City of Albuquerque Stormwater Construction Site Inspection Report

General Information					
ESC File No.	D17E095A	Project Name:	Guthrie's Garage		
NPDES Id. No.	NMR1005KO	Location:	3831 Masthead Street		
8/2/2023	Owner	Contractor NMR1005M8			
Operator	Headstart Enterprises LP		Wilger Enterprises		
Contact name & title	Jim Guthrie		John Wilger		
e-mail	jim@carcrafters.com		iwilger@wilger.com		
Contact Phone #	881-8889		505-345-2854		
COA Inspector	Doug Hughes		Start/End Time:	11:45AM	
Construction Phase:	Cleared				
Type of Inspection:	Regular	Storm Event	Post Storm Event >0.25"	311/Complaint	Follow Up
Weather at time of inspection?	Cloudy		Temperature: ~	98	
Estimated date of last storm 0.25" or greater	8/8/2023

ENGINEER'S SEAL RONALD R. BOHANNAN NEW MEXICO PROFESSIONAL ENGINEER 7868 4-17-23 RONALD R. BOHANNAN P.E. #7868	3831 MASTHEAD ST ALBUQUERQUE, NM	DRAWN BY pm
EROSION CONTROL PLAN		DATE 4-17-23
		DRAWING
		SHEET # SW-1
		JOB # 2022002

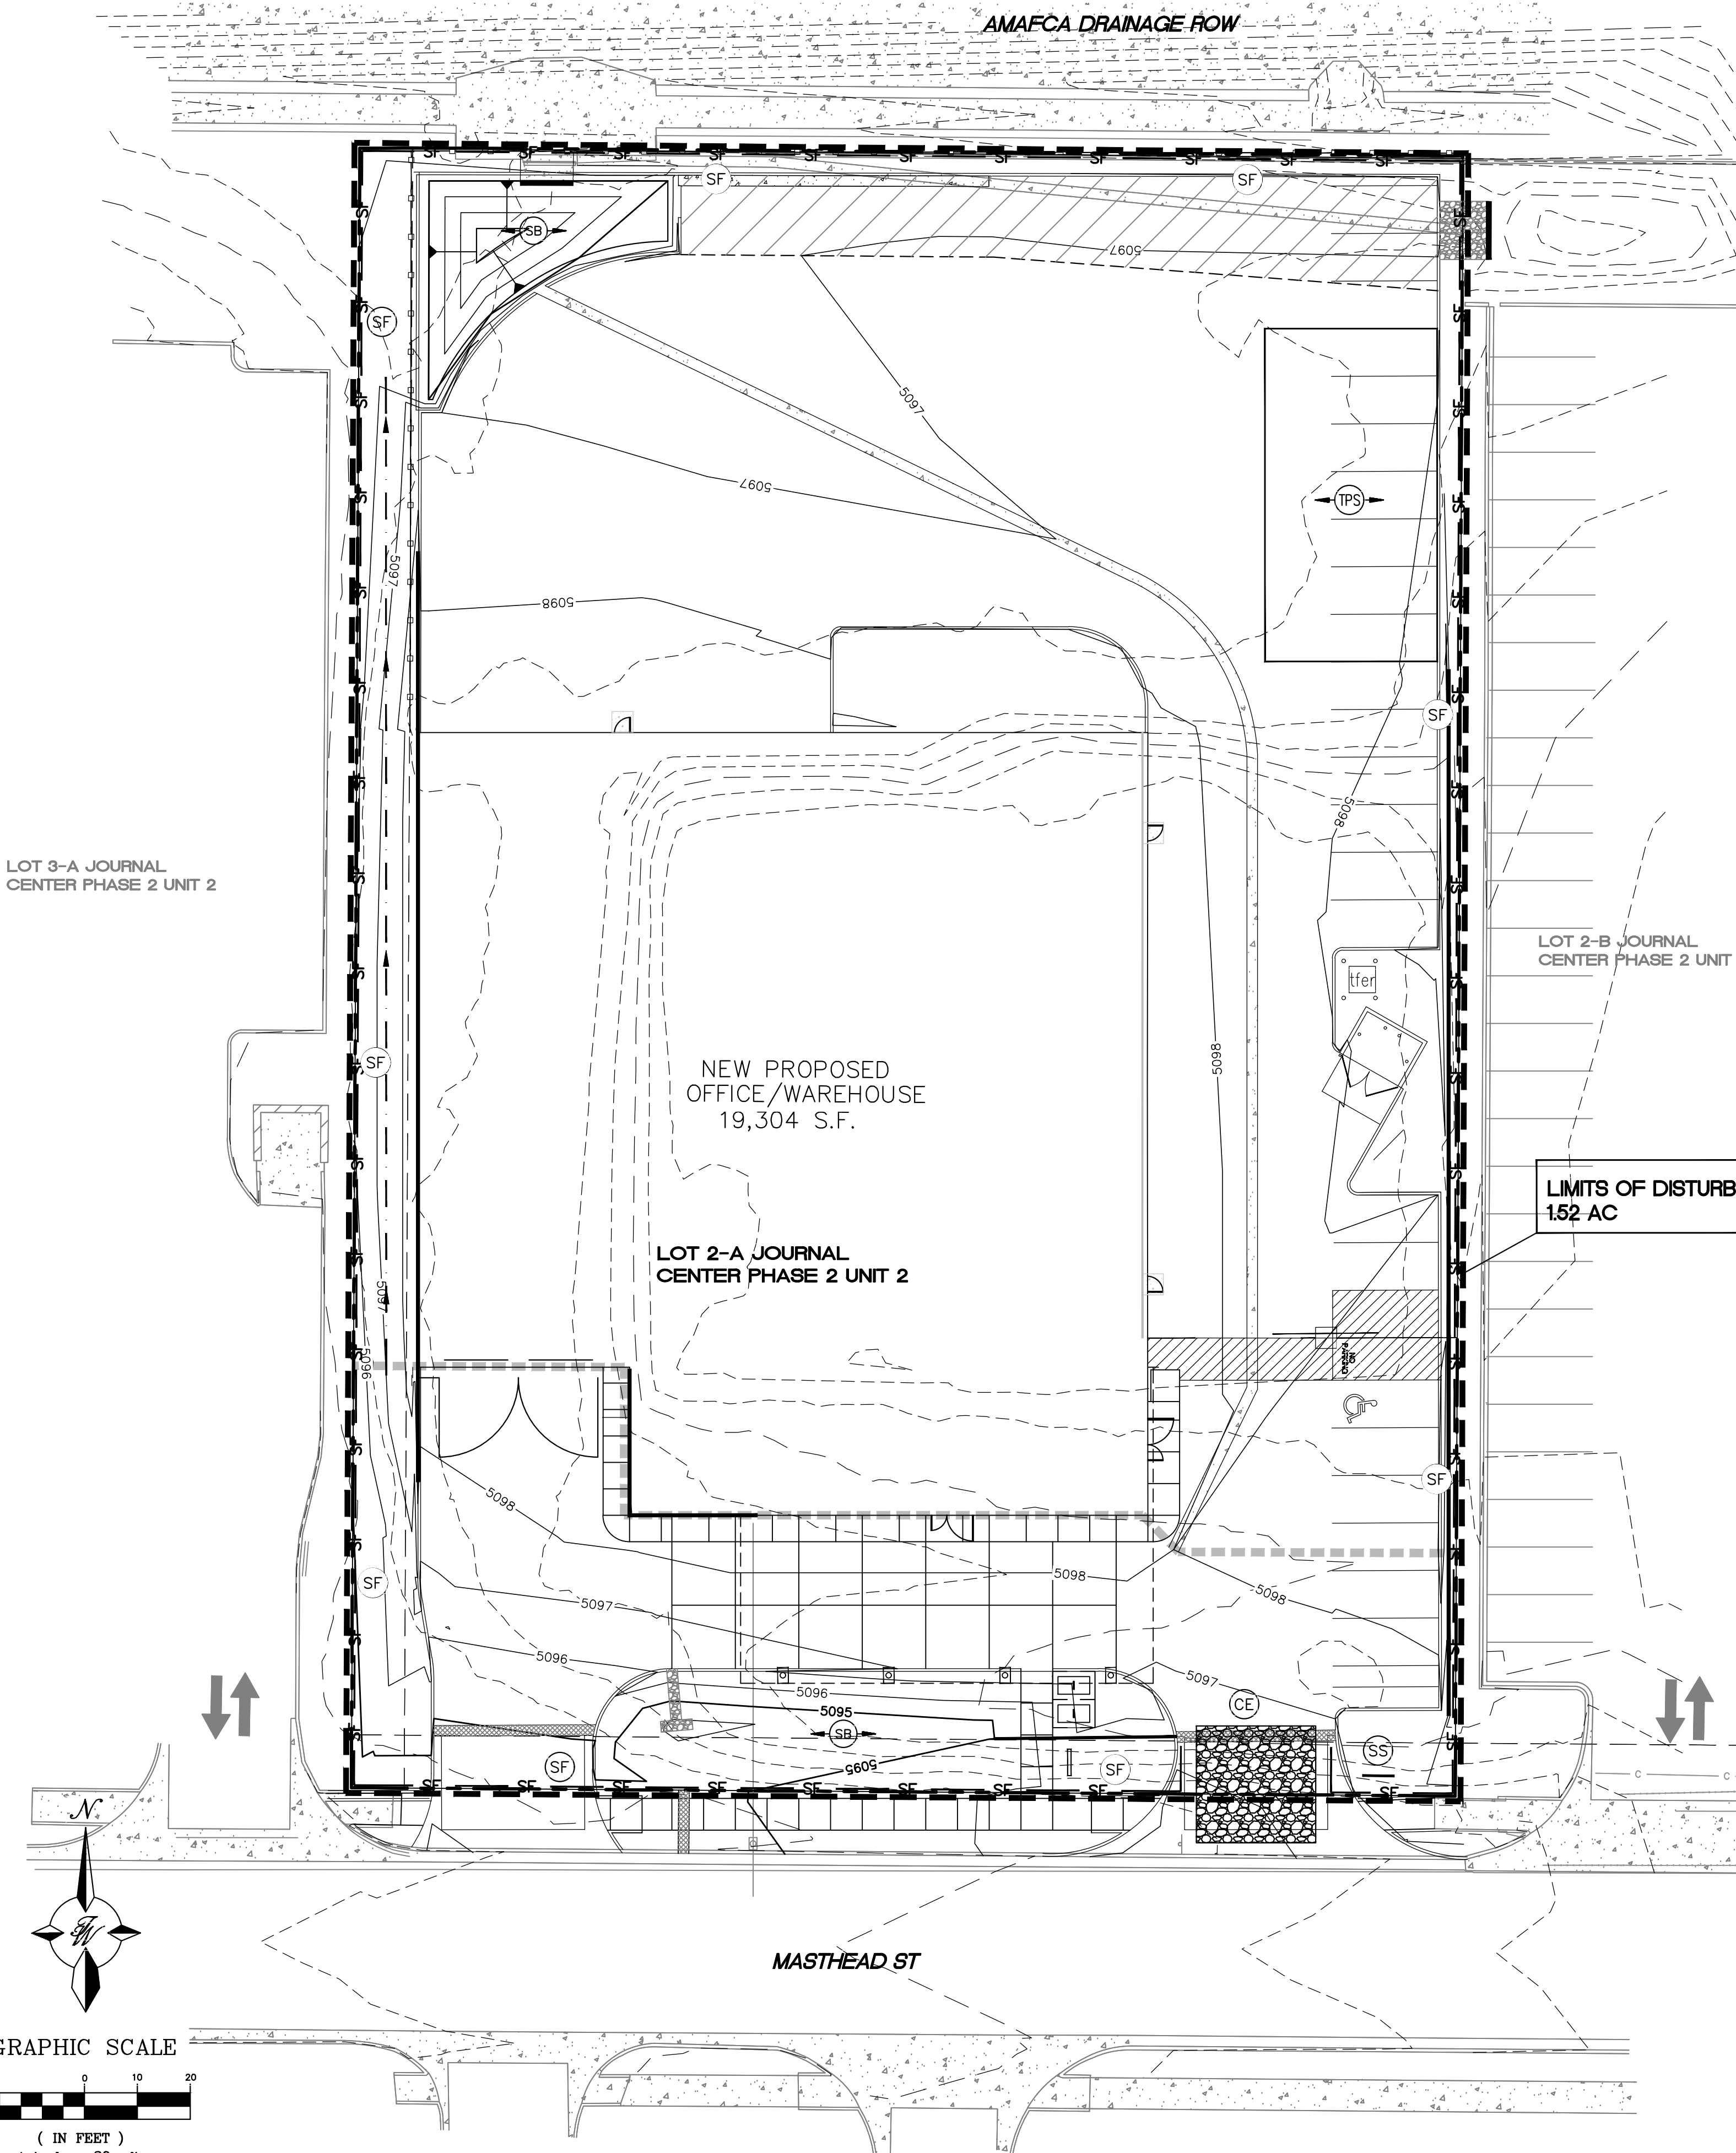
2	<p>2. BMPs – SF was missing at the north outfall, down in the northwest and southwest corners, in need of repair and full along the west side of the site, and the CE was in the wrong place (i.e., the lowest corner of the site). Similar areas of concern were reported during the previous city inspection on 7/12/23 and during your self-inspection on 7/27/23.</p>
